## Crown Sydney - Response to Submissions

The following document provides responses to issues raised in relation to the transport study supporting the Crown Sydney development application.

**Figure 27: CSHR forecast traffic generation/distribution at the AM (left) and PM (right) peaks (Base source: Applicant's RtS)**

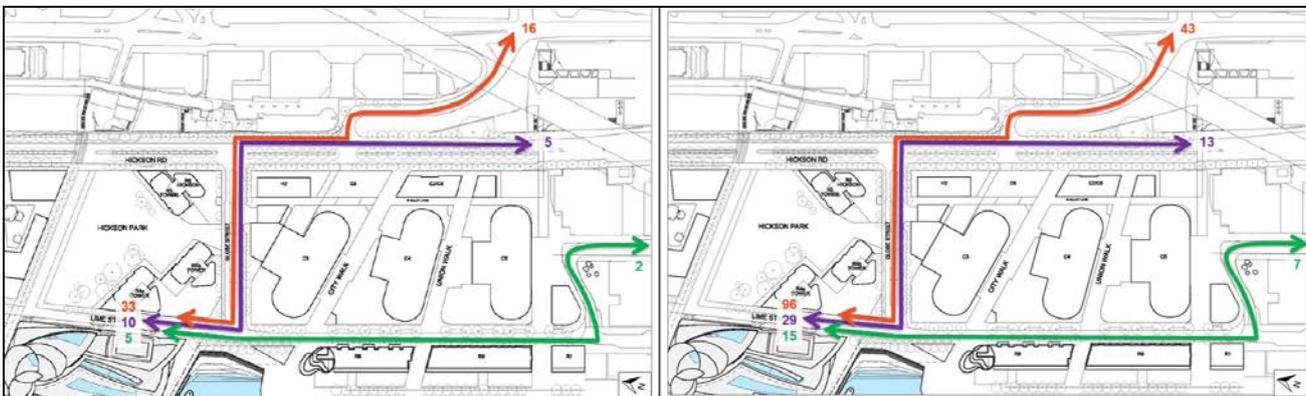
***No detailed information is provided on how the generated traffic would be distributed along Hickson Road. Future AM and PM peak periods should be reported.***

The forecast traffic distribution associated with Crown Sydney is illustrated in Figure 23 (for the AM peak hour) and Figure 24 (for the PM peak hour) of the updated traffic assessment.
